Further WSCC Highways comments

Re-consultation Request for Emma Avis

Site Plan -
Proposed

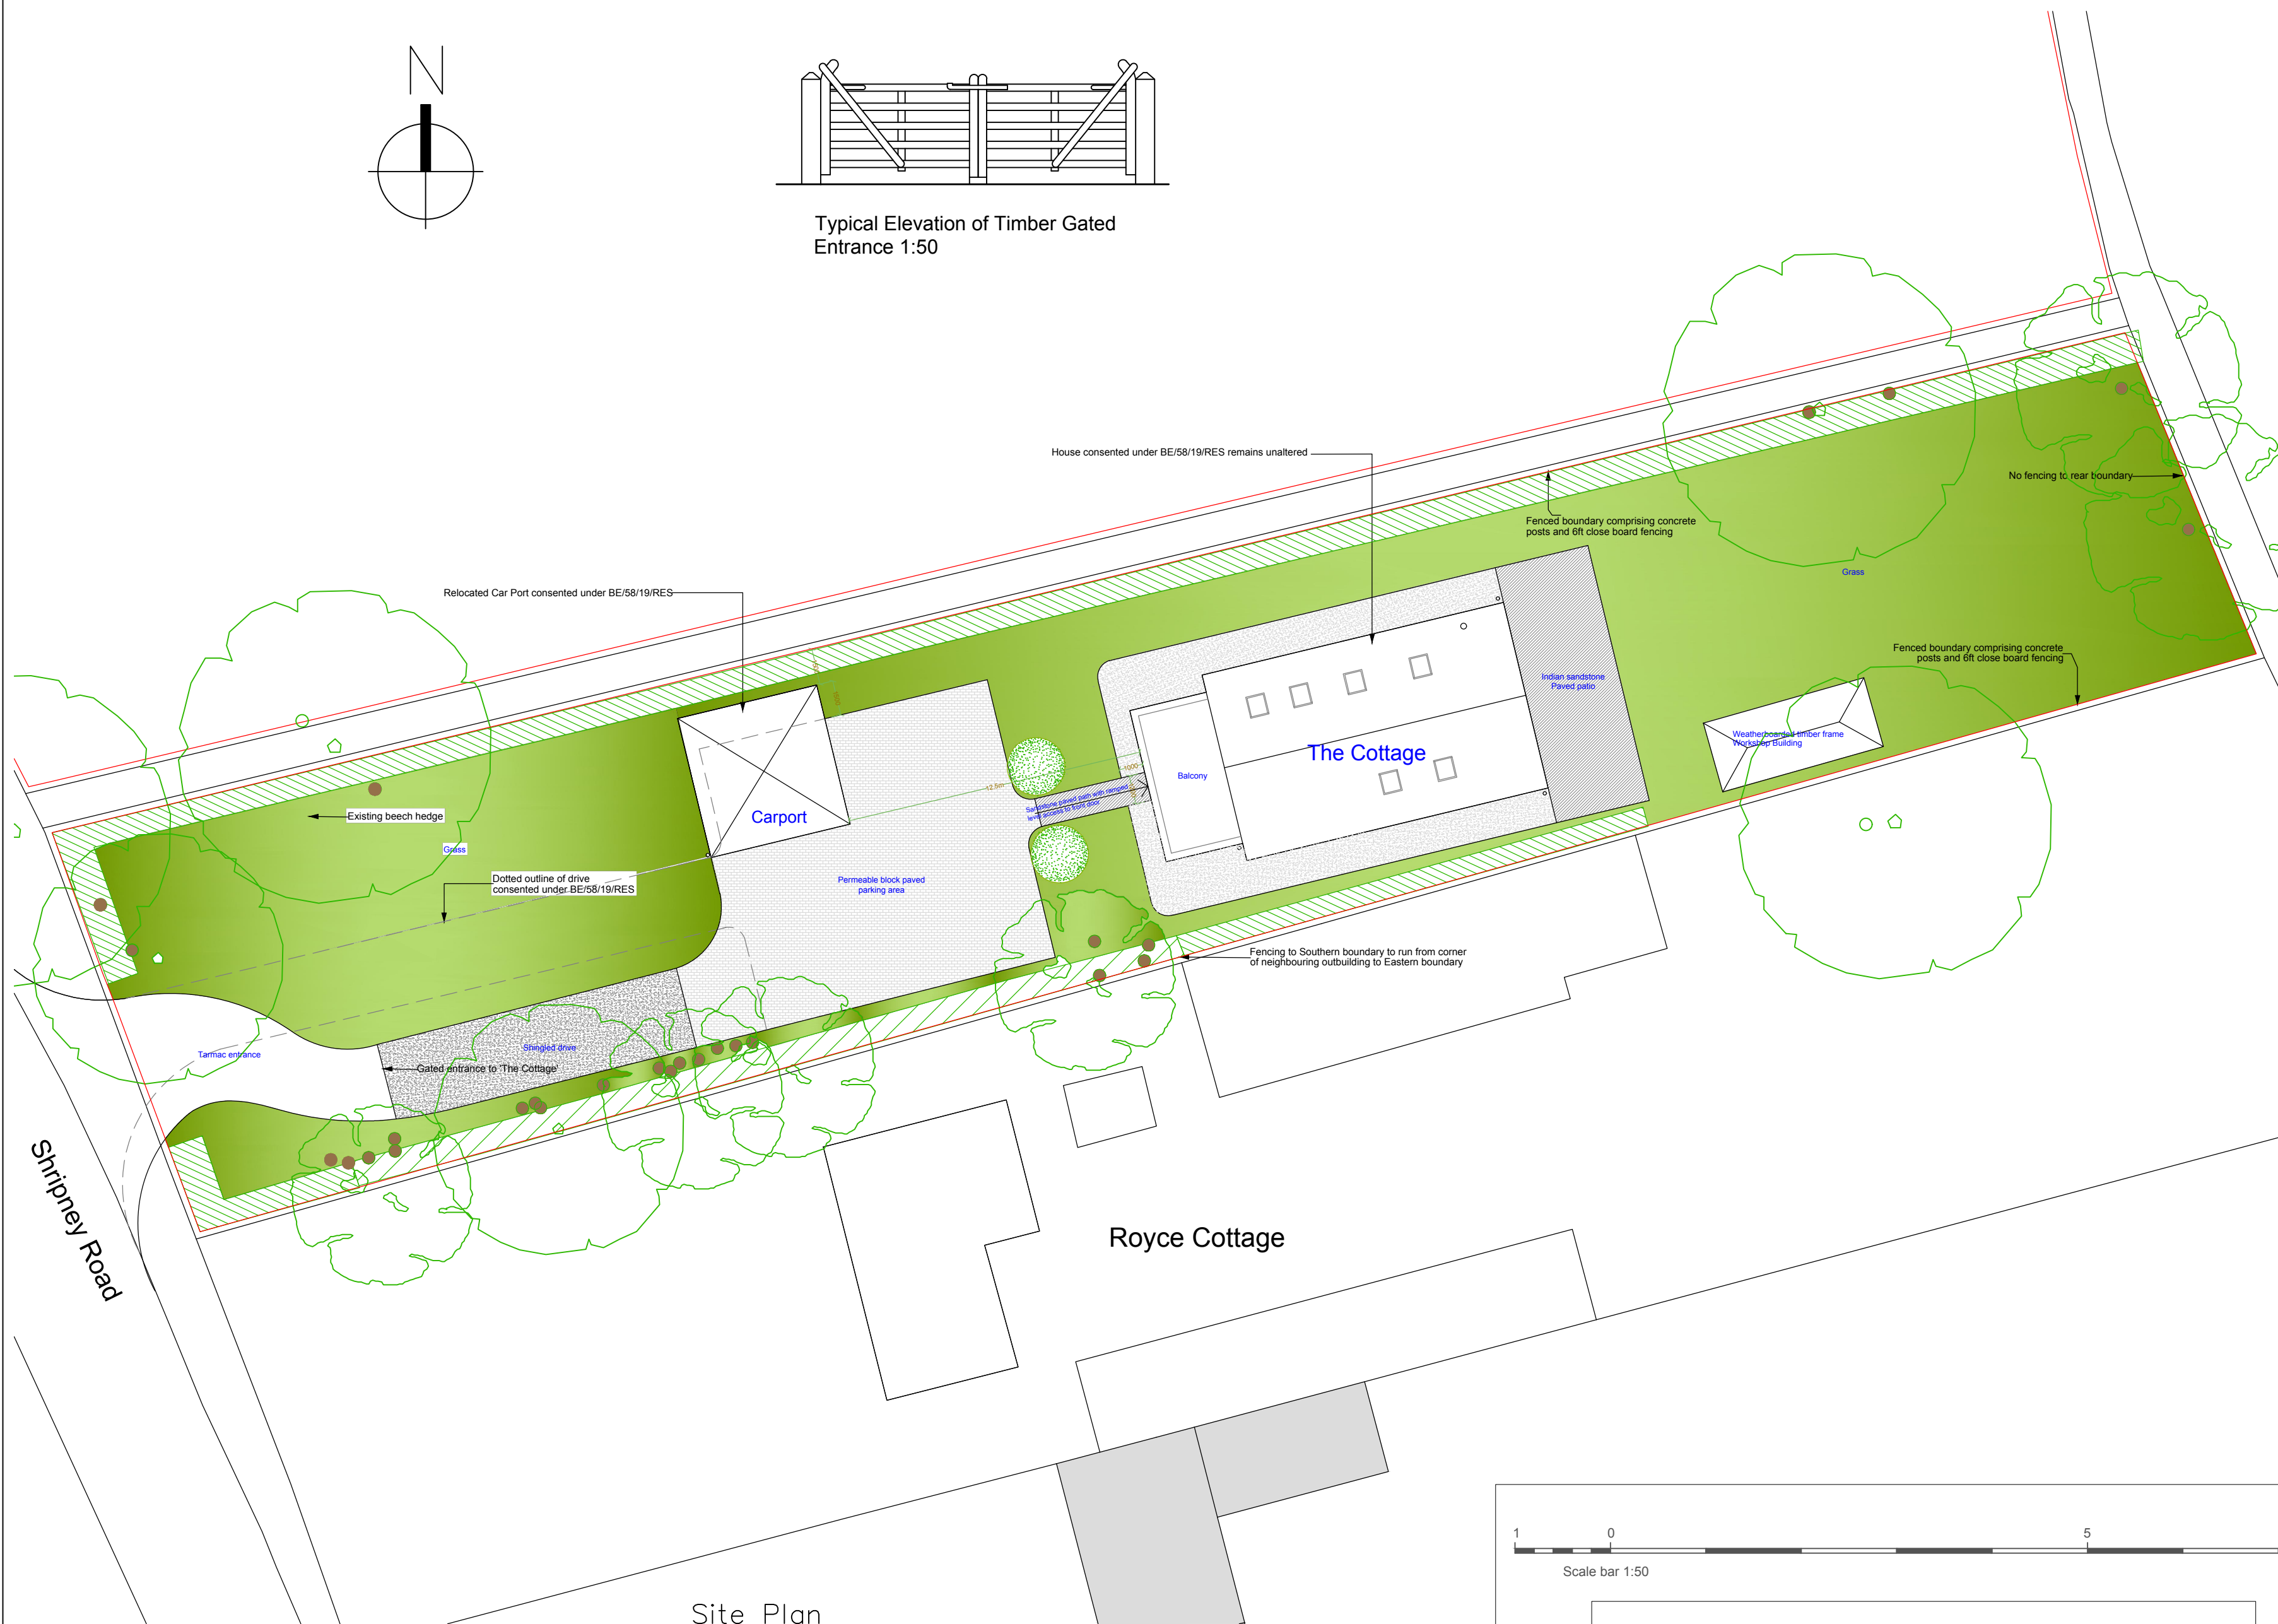
As long as the access is not changing from that previously approved then the LHA would raise no concern to the proposals. I think as you suggest below an informative should be added to insure this.

In response to your consultation comments of 28/08/20, I do agree that it looks on the plans (when comparing this versus approved) like the access is changing slightly. However, the applicant has confirmed (as attached) that there are no changes to the access.

We could add an informative that states that the Planning Permission does not authorise any changes to the access which was approved by BE/63/17/OUT (as amended by BE/131/18/PL) and any changes to it would need to be agreed through a variation of the outline permission.
